THE GARDENS AT NORTH CAREFREE PRE DEVELOPMENT GRADING AND EROSION CONTROL PLAN EL PASO COUNTY, STATE OF COLORADO

**THE GARDENS AT NORTH CAREFREE
GRADING & EROSION CONTROL PLAN**

**THE GARDENS AT NORTH CAREFREE
 GRADING & EROSION CONTROL PLAN**

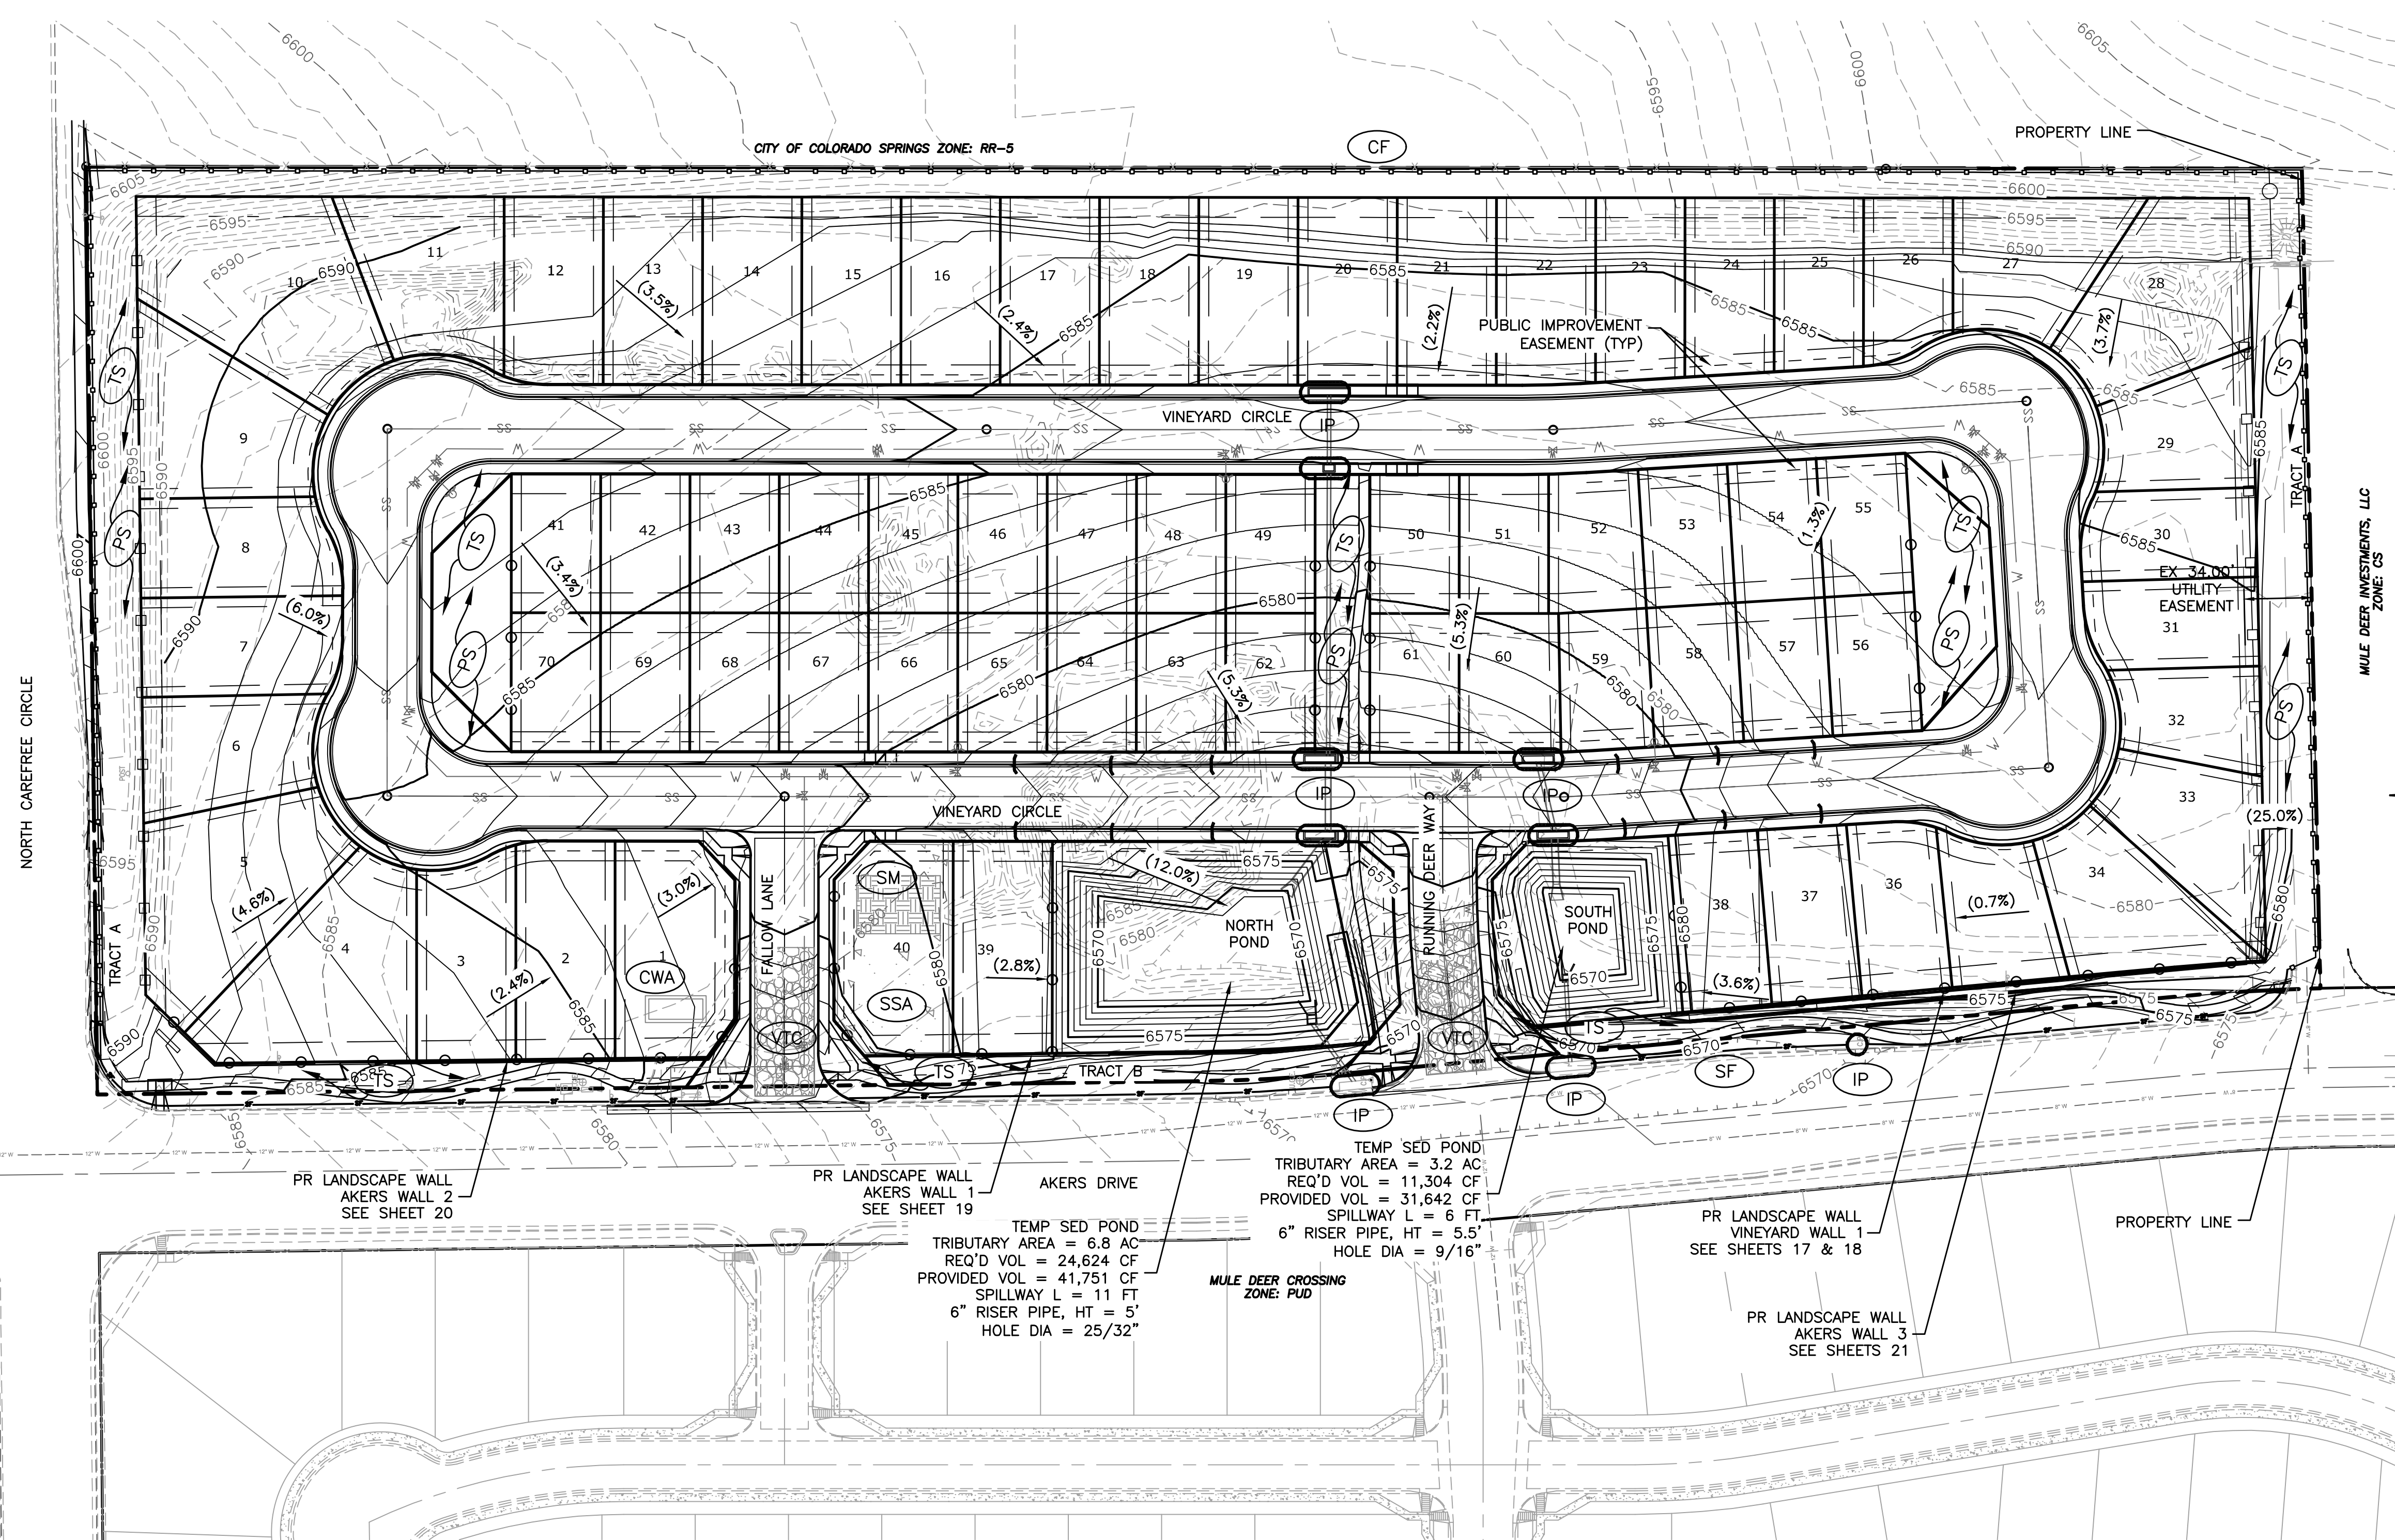
Please tie-in the contour to the existing contour
